City of Albuquerque Stormwater Construction Site Inspection Report

General Information					
ESC File No.	H13E109A	Project Name:	Sandia Lab FCU		
NPDES Id. No.	NMR1004MR & '4U0	Location:	1100 Rio Grande Blvd NW		
5/8/2023	Owner	Contractor			
Operator	Garcia Real Estate Investments, LLC		Insight Construction		
Contact name & title	Ed Garcia		Dave Brown		
e-mail	eedgarcia@garciacars.com		Dave@insightnm.com		
Contact Phone #	505-259-0339		505-506-8412		
COA Inspector	Doug Hughes		Start/End Time:	10am	
Construction Phase:	WO complete and BP vertical				
Type of Inspection:	<input type="checkbox"/> Regular	<input type="checkbox"/> Storm Event	<input type="checkbox"/> Past Storm Event >0.25"	<input type="checkbox"/> 311/Complaint	<input checked="" type="checkbox"/> Follow Up
Weather at time of inspection?		clear		Temperature: ~	70
Estimated date of last storm 0.25" or greater		3/16/2023

RONALD R. BOHANNAN P.E. #7868	<b>SANDIA LAB FCU</b> <b>RIO GRANDE AND I-40</b> <b>SWPP PLAN</b>	DRAWN BY LN
		DATE 06/23/21
		2012100-SWPPP
		SHEET # <b>C6.1</b>
 <b>TIERRA WEST, LLC</b> 5571 MIDWAY PARK PLACE NE ALBUQUERQUE, NM 87109 (505) 858-3100 www.tierrawestllc.com		JOB # 2012100

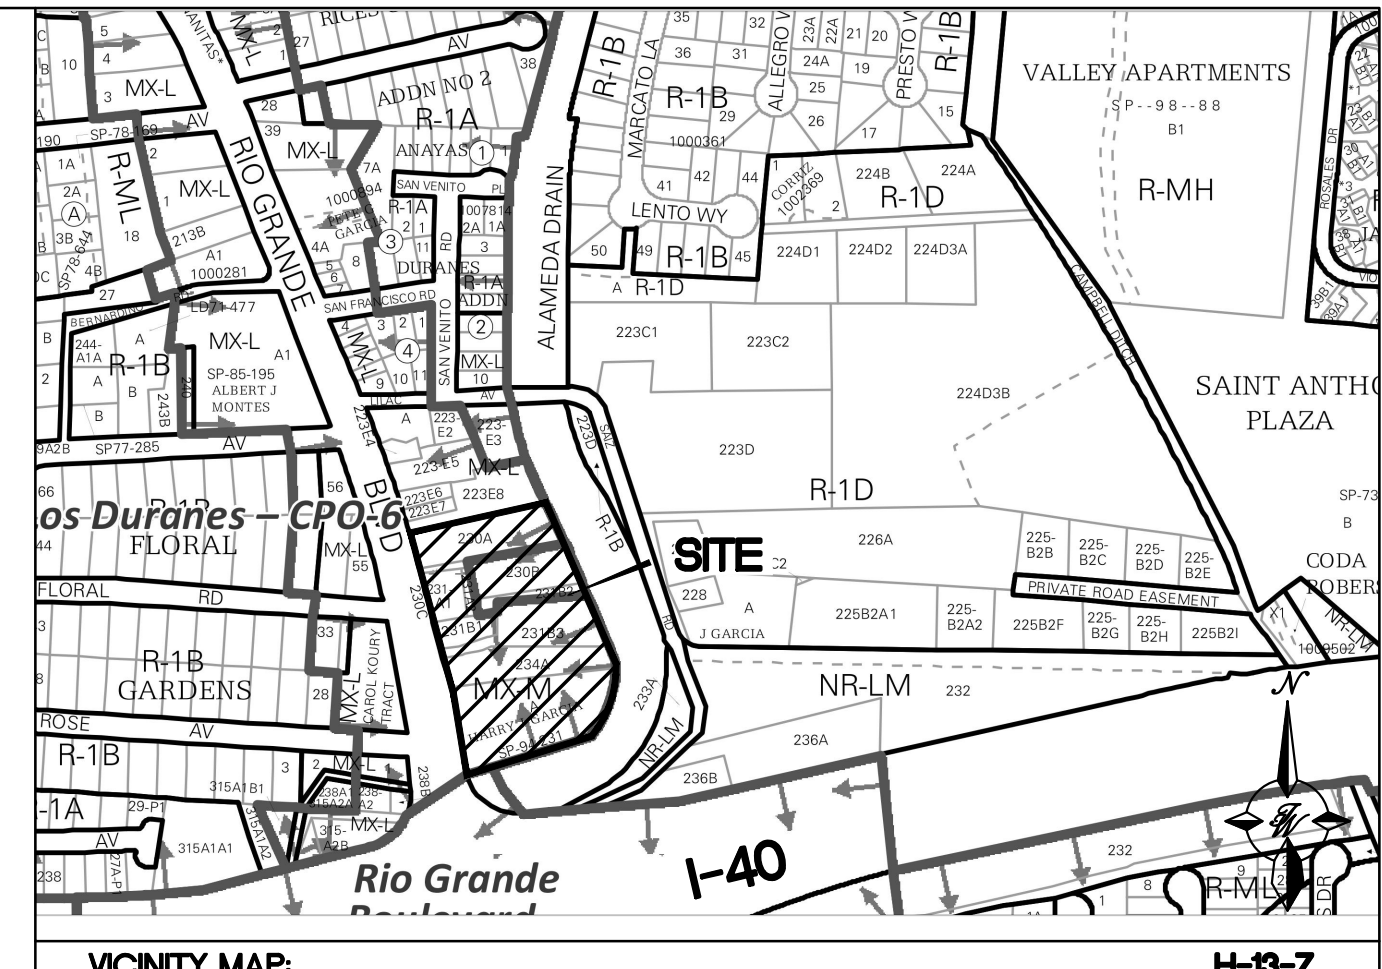
Notes: The SWPPP is in the conex on site. It contains the property owner's NOI, the CGP, and some old self-inspection reports (most recent is 8/24/22). The SWPPP map needs updated. The Property

SWPPP INFORMATION SIGN (S)  
N.T.S.

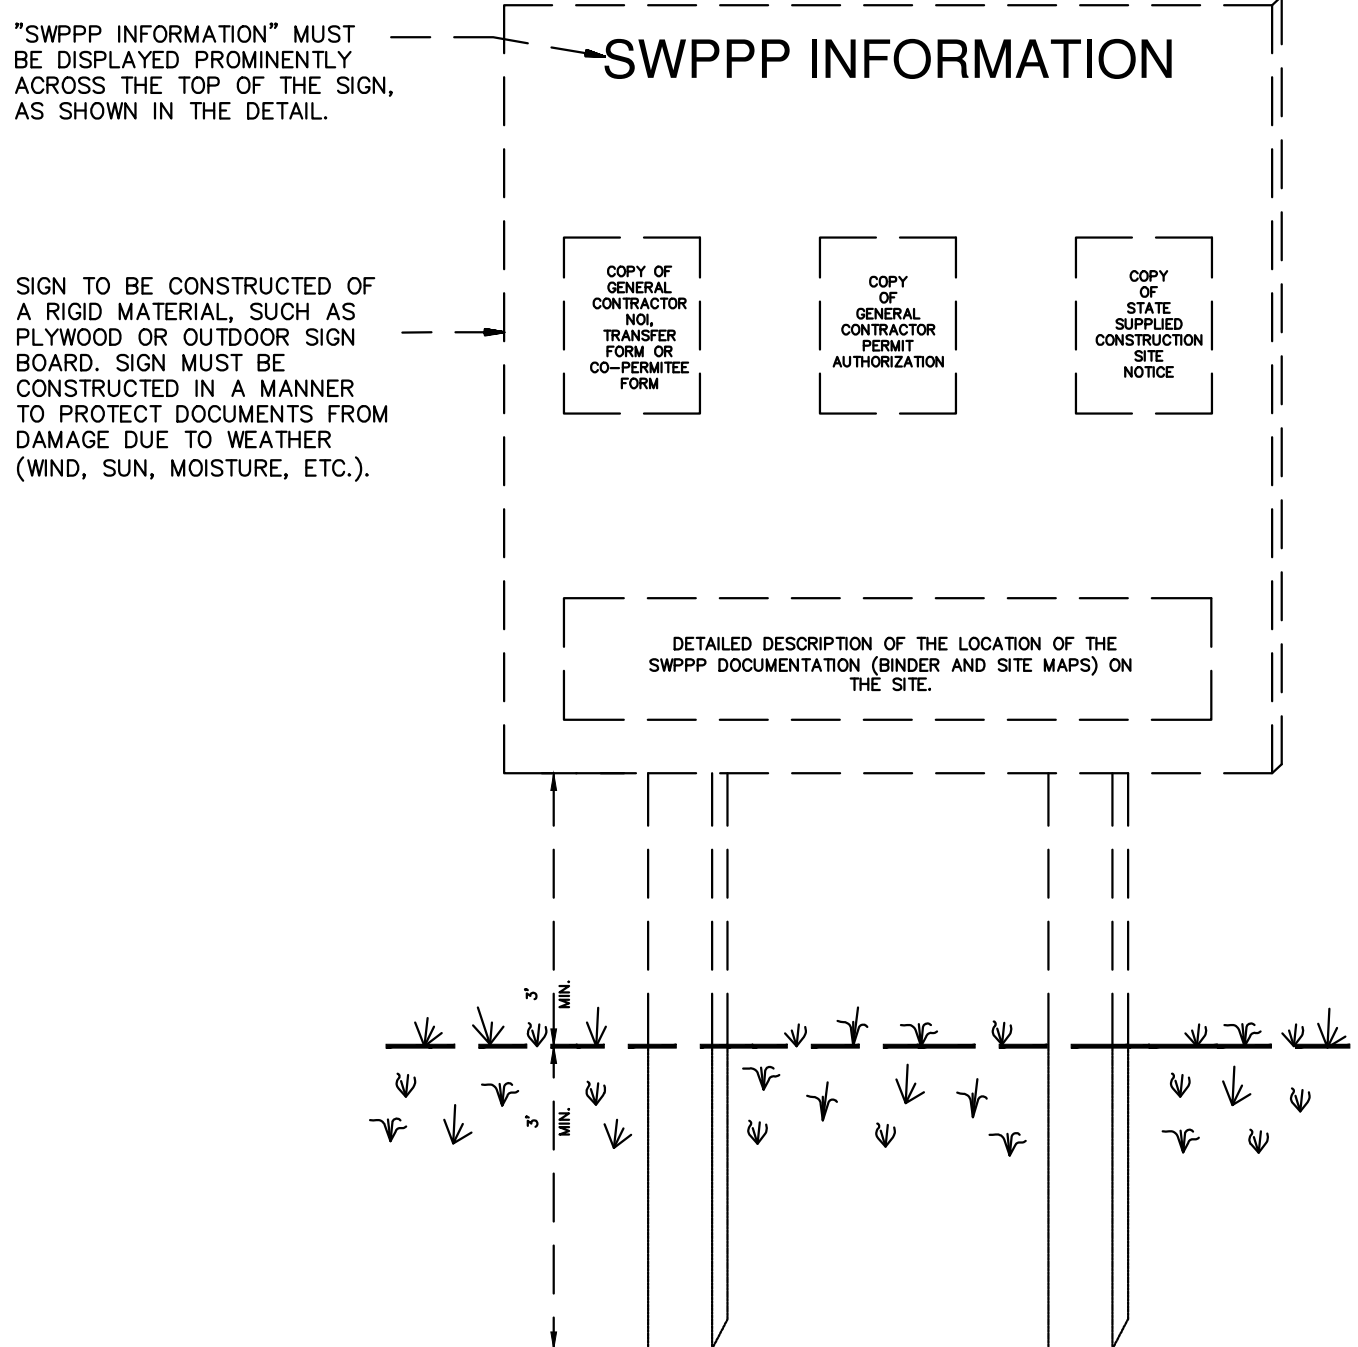
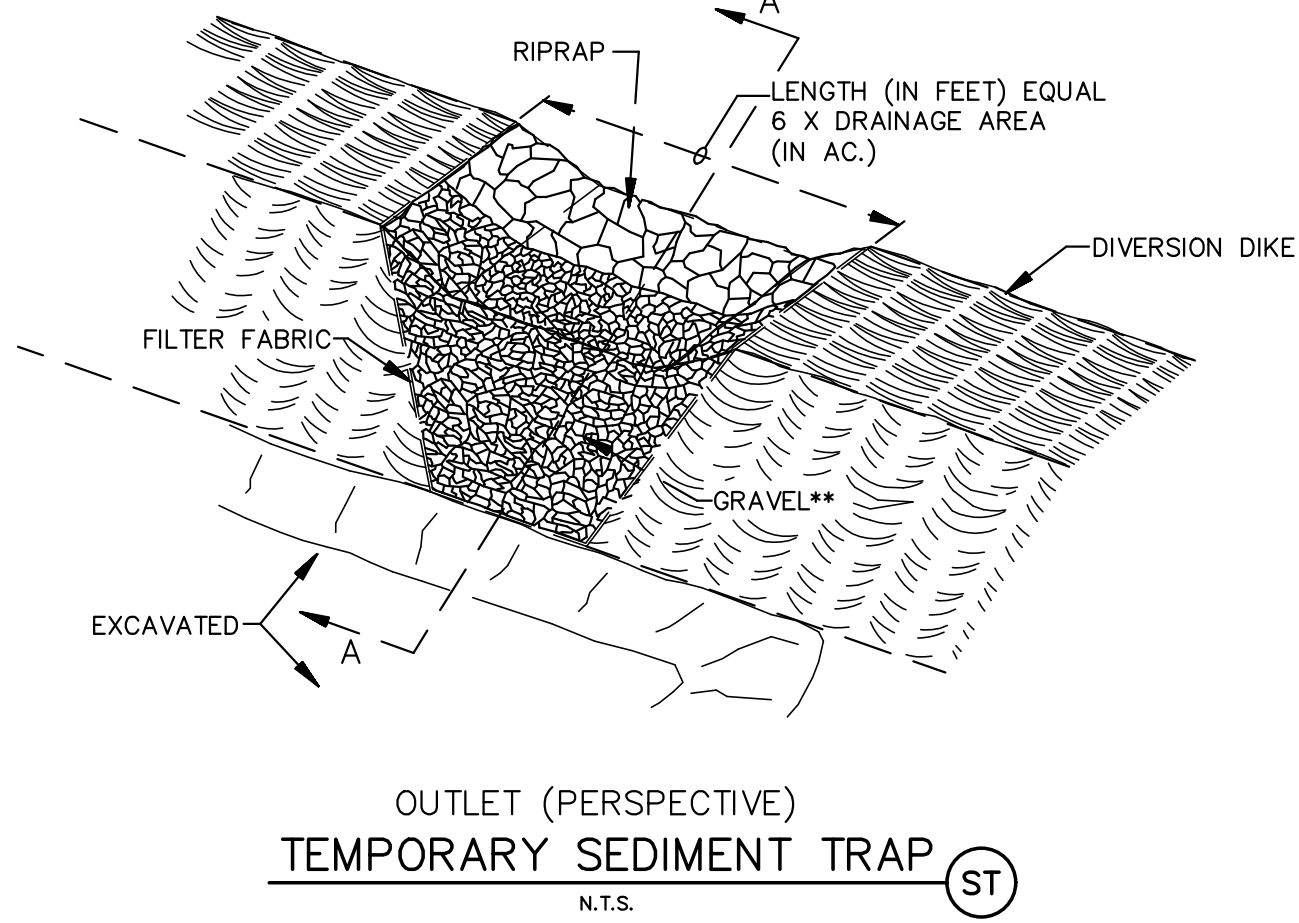
Item Number	Deficiency/ Corrective Action				
1	Posting - Incomplete and wrong place. The NPDES ID # and point of contact are missing and must be included on the sign. You must post a sign or other notice of your permit coverage at a safe, publicly accessible location in close proximity to the construction site. The notice must be located so it is visible from the public road that is nearest to the active part of the construction site, and it must use a font large enough to be readily viewed from a public right-of- way per CGP 1.5.				
2	Conduct self-inspections Once every 14 calendar days and within 24 hours of the occurrence of a storm event of 0.25 inches or greater per CGP 4.2 and City ESC Ordinance § 14-5-2-11(C)(1) until final acceptance of site stabilization by the city. Keep signed copies of Self-inspection reports per CGP 4.7 and Corrective Action reports per CGP 5.4 with the SWPPP on-site, and provide a copy via e-mail to me.
